Reference No:	2024/62/90450/W
Site Address:	14, Lincroft Avenue, Dalton, Huddersfield, HD5 8DS
Description:	Erection of single storey side and rear extensions
Recommending Officer:	Molly Storer

HOUSEHOLDER DELEGATED REPORT

Application Number	2024/90450
Location	14, Lincroft Avenue, Dalton, Huddersfield, HD5 8DS
Proposal	Demolition of existing single storey rear extension and erection of single storey side and rear extension.
Publicity end date	29 th March 2024
Number of representations received	Two.
Kirklees Local Plan Allocation/Designation	Unallocated in the Kirklees Local Plan
Extension to Time (EoT)	Yes EoT Date: 26/04/2024
Recommendation	Conditional Full Permission

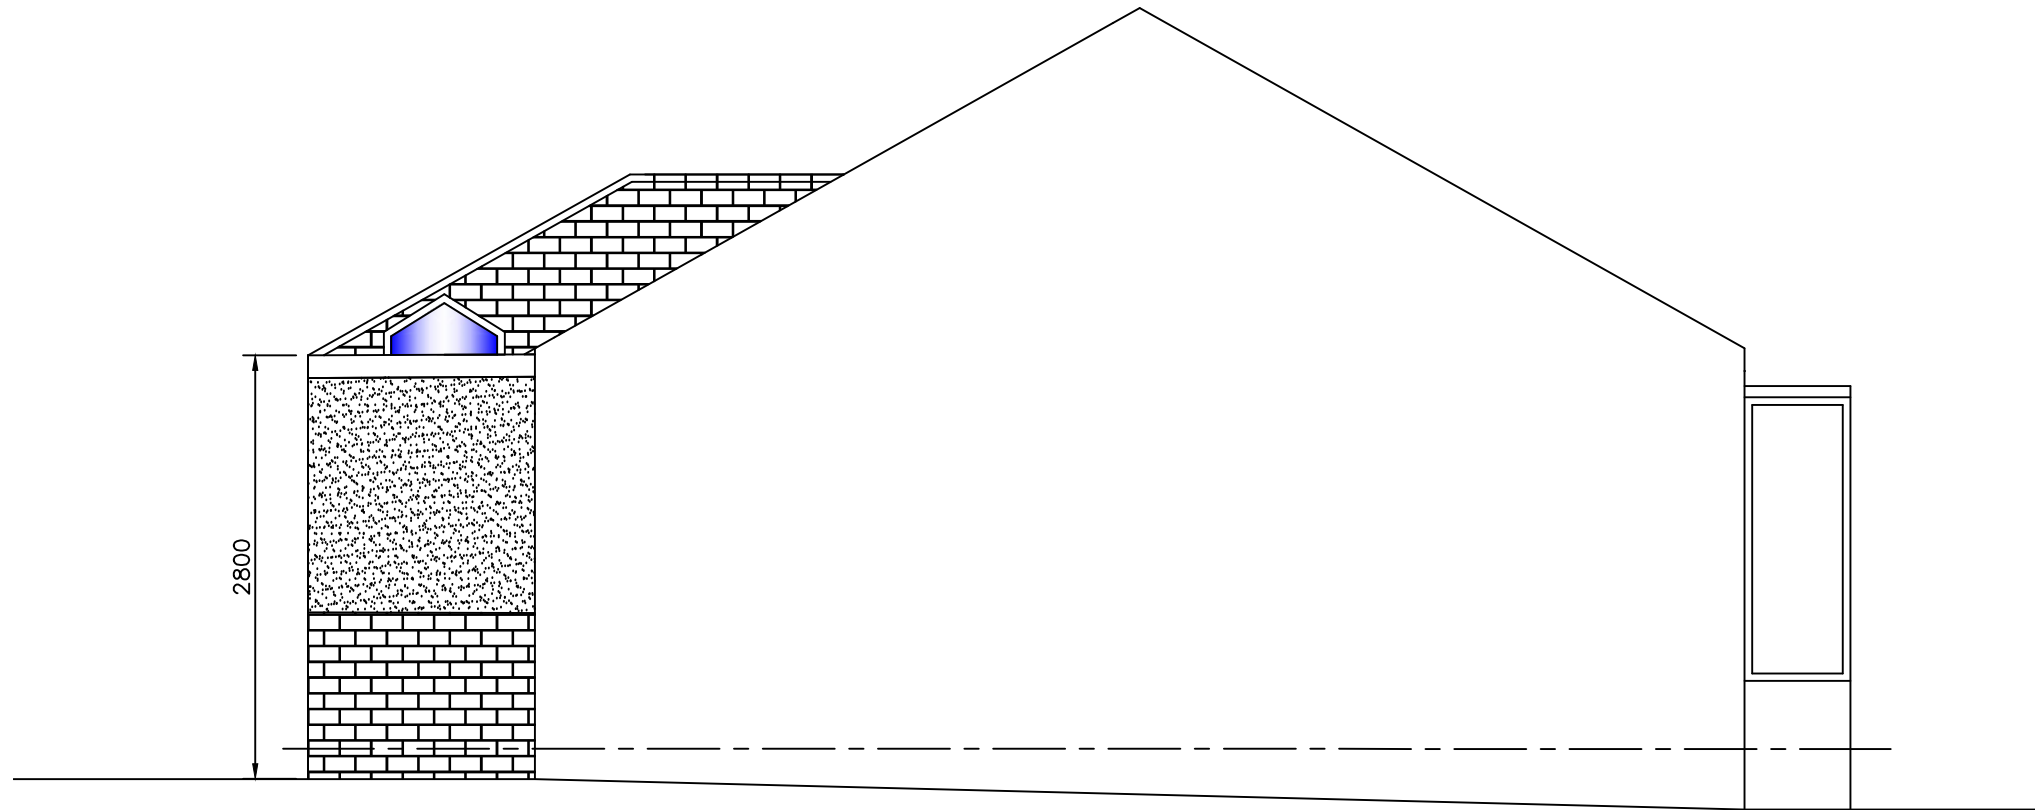
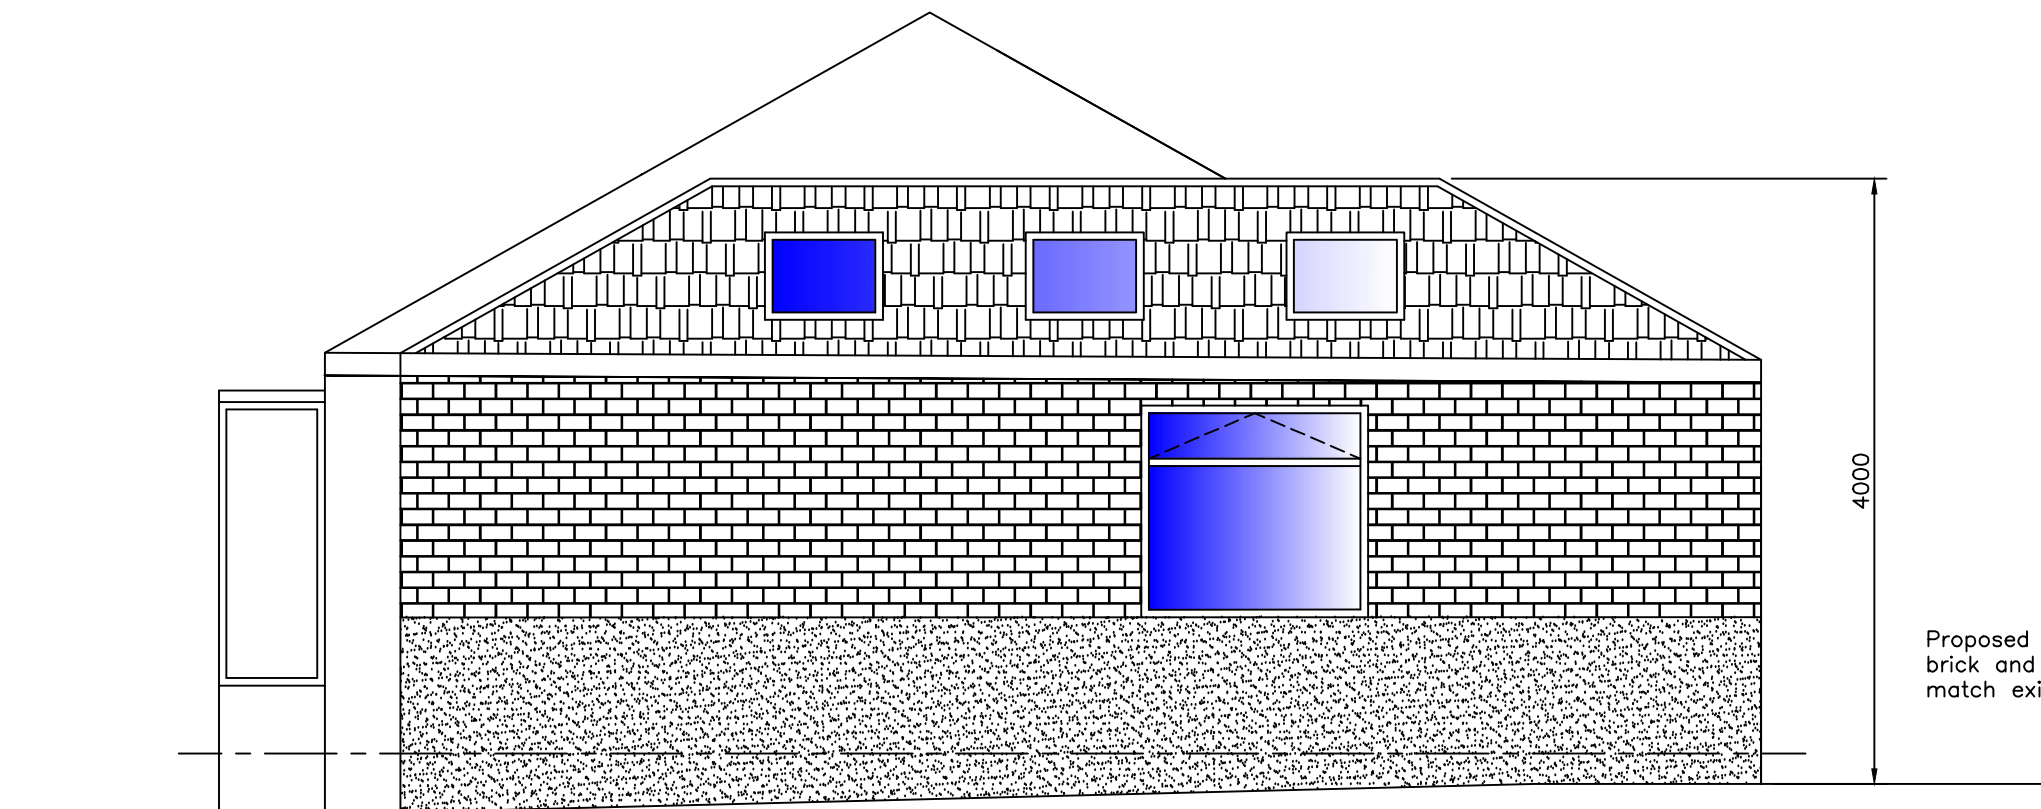
The single storey side extension will project 3m from the north facing side elevation and will have a length of 7.4m, being set back from the front elevation by 0.5m. the roof will be of a gable roof design to match that of the existing property. The height to the eaves will be 3m with an overall height of 4.7m.

Chapter 12 of the NPPF	that of the original dwelling.	
Window proportions	- KDP 1 and 2 of the SPD - Policy LP24 Design (a), (c) and (d) of the KLP - Chapter 12 of the NPPF	There will be one large window on the front (east) elevation and side (north) there will be 3 windows. On the rear (west) elevation plans show there will be large bi folding doors to the rear extension and a single window and door on the side extension. glazing will not cause any further significant harm. There will be a roof lantern in the rear extension and no openings in the side south facing elevation.	✓
Accessibility for all users	- KDP 17 of the SPD - Policy LP24 Design (f) - Chapter 12 of the NPPF	Private domestic extension – no alterations to general access arrangement. External access to the rear of the property will remain.	✓

Relevant key design principle (KDP) of the SPD, Policy in the Kirklees Local Plan and the NPPF	Further comments	✓ / X / N/A
Impact on privacy of neighbours (to sides, rear and front)	• KDP 3 & 4 of the SPD • Policy LP24 Design (d) (iv) • Chapter 12 of the NPPF	There will be no openings within the south elevation facing No.16. Therefore the development will not cause significant impact to this neighbours privacy.	✓
Impact on light and outlook of neighbours (to sides, rear and front)	• KDP 4, 5, 6 of the SPD • Policy LP24 Design (b) • Chapter 12 of the NPPF	The rear extension will not extend beyond the extension at No.16 therefore will not be significantly overbearing. Although No 14 is set on a higher ground level, due to the orientation of the houses and the limited projection of the extension there will only be minimal shading to the garden of No.16 in the late afternoon, this is not considered reason for refusal.	✓

3. Notwithstanding the plans submitted the external walls of the extensions and roofing materials of the side extension hereby approved shall in all respects match those used in the construction of the existing building and be retained thereafter.

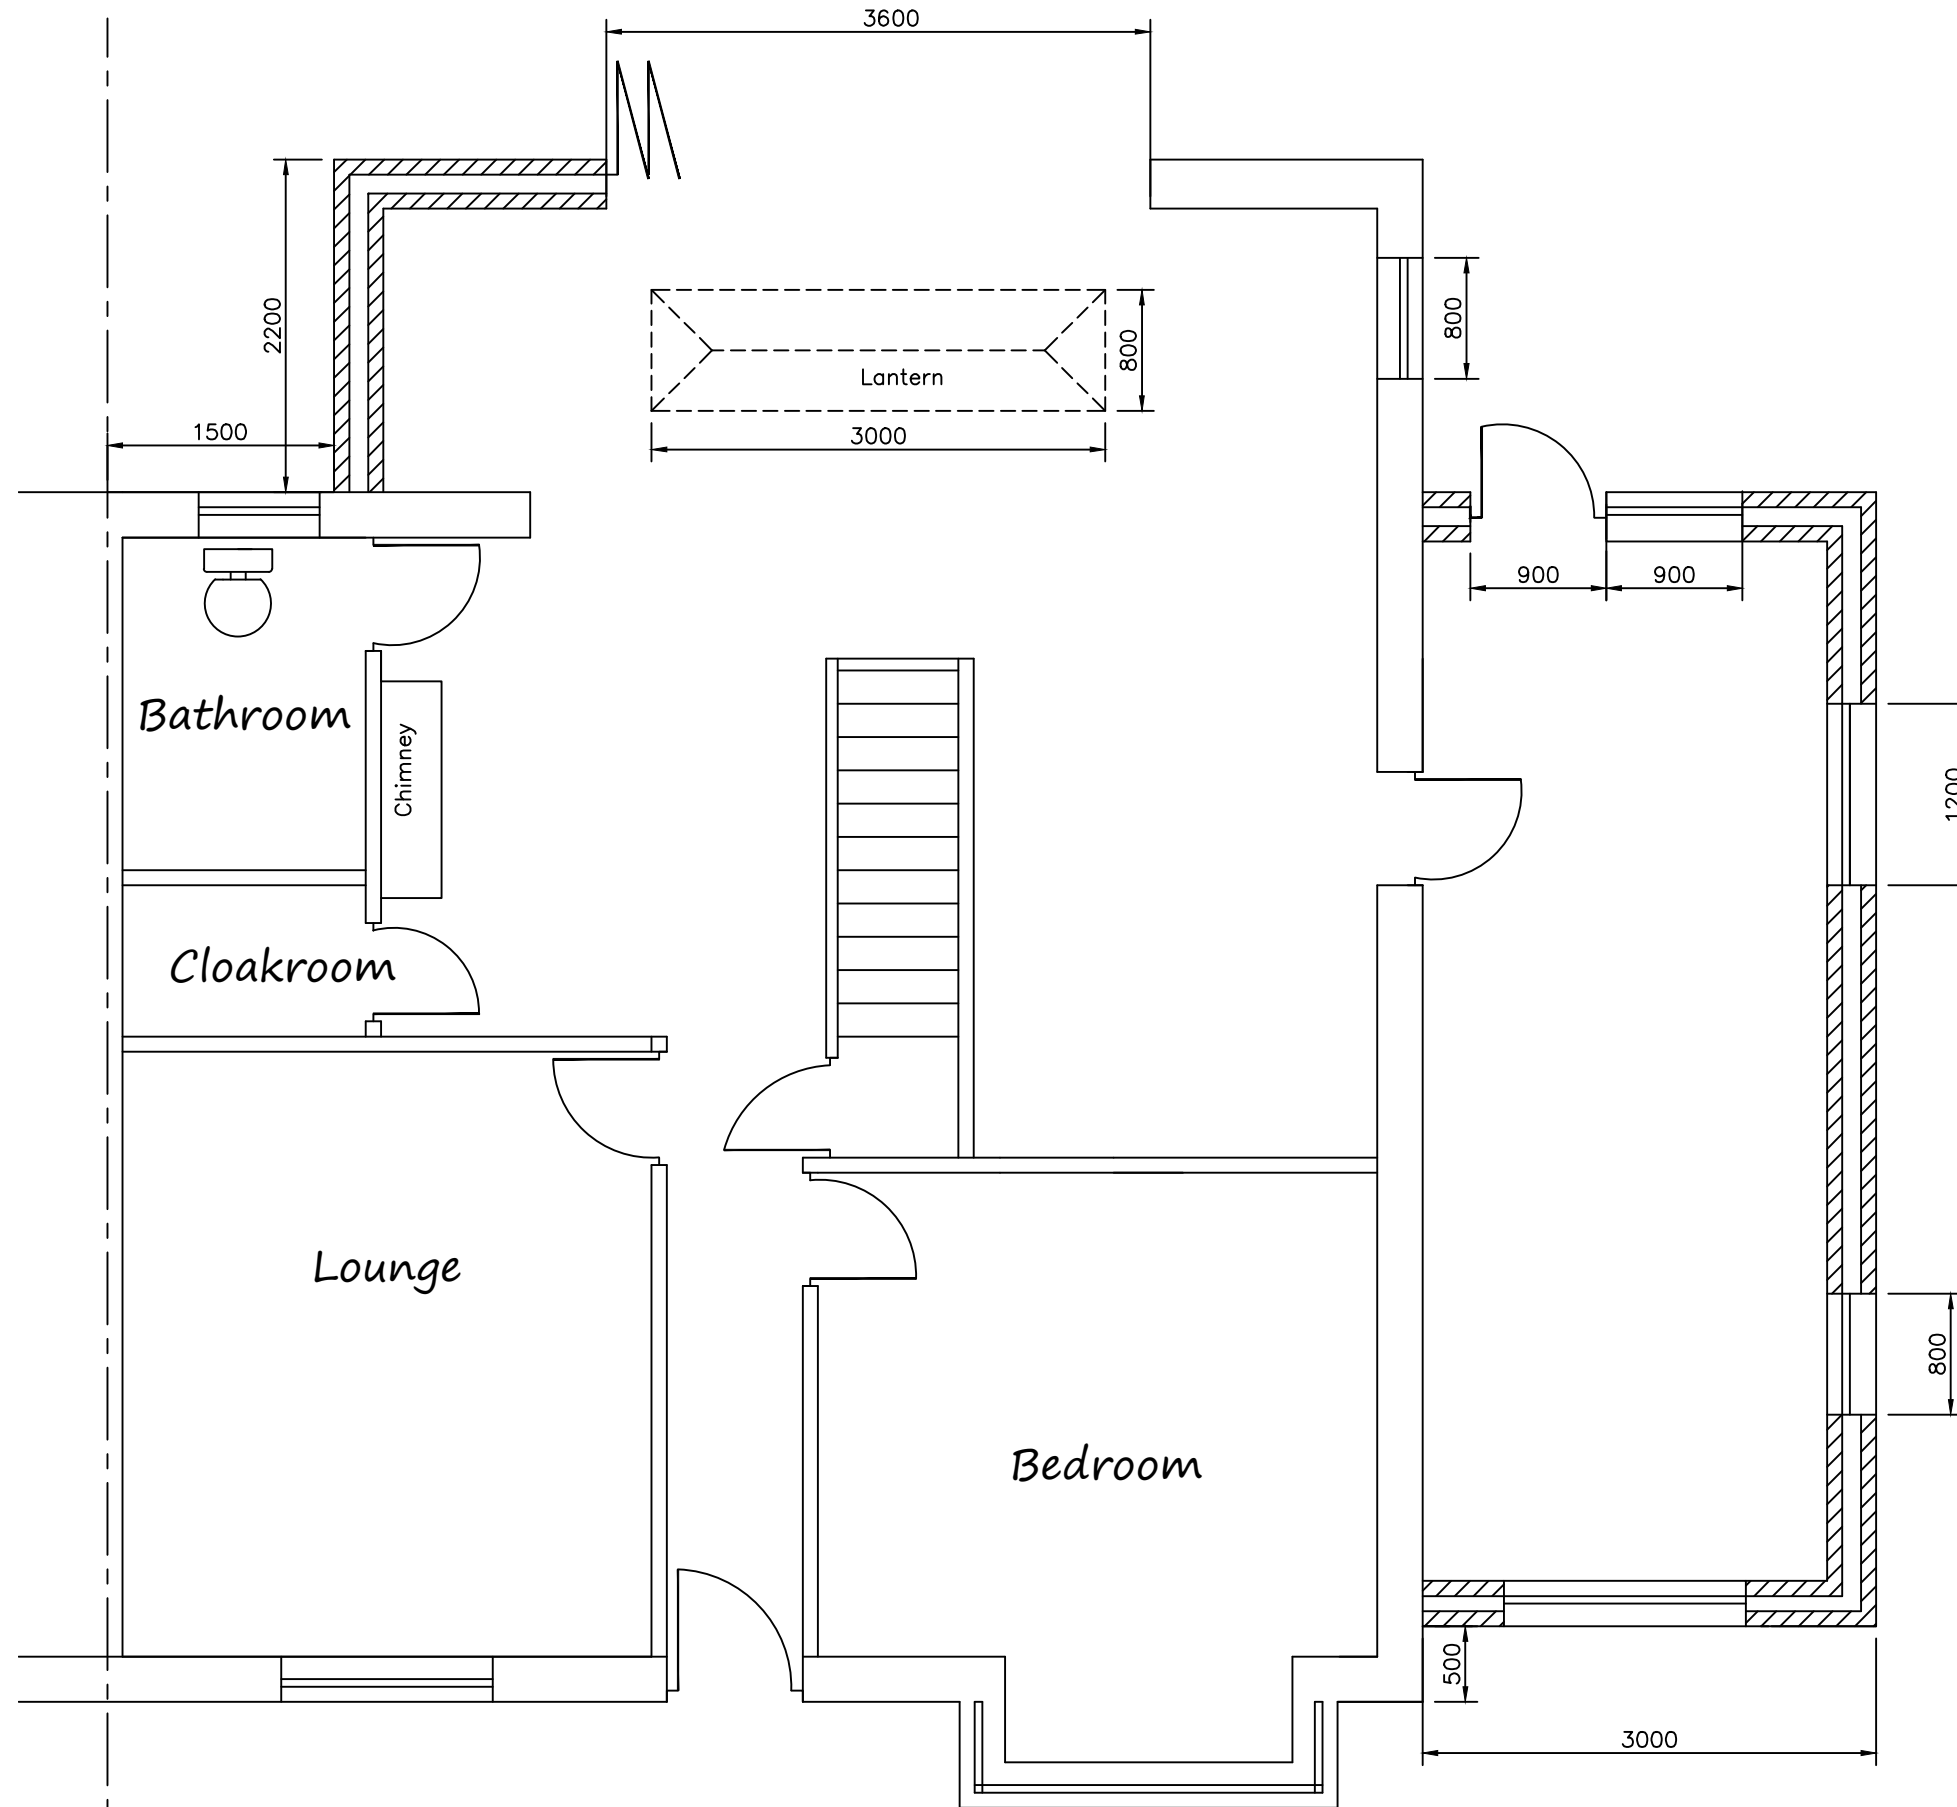
The single storey rear extension will project 2.2m from the rear wall of the house and will have a length of 7.2 meters, it will have a flat roof design with an overall height of 2.8m.

Although it would have a flat roof, replacing an existing catslide, given the siting and scale of the extension, this is considered acceptable.	
not normally cover more than half the total area around the original house (including previous extensions and outbuildings)	Yes – the extension will not cover more than half of the total area around the original house.	
not exceed 4 metres in height	Yes – the height of the extension will be 2.8m.	
not project out more than 3 metres from the rear wall of the original house for semidetached and terraces houses or by 4 metres for detached properties	Yes – the property is semi-detached and the projection will be 2.2m from the rear.	
where they exceed 3m in length the eaves height should generally not exceed 2.5 meters	N/A – the extension will not exceed 3m in length.	
retain a gap of at least 1 metre from a property boundary, such as a wall, fence or hedge	Yes – a gap of 1.5m will be retained between the side elevation of the extension and the boundary wall with No.16 Lincroft Avenue.
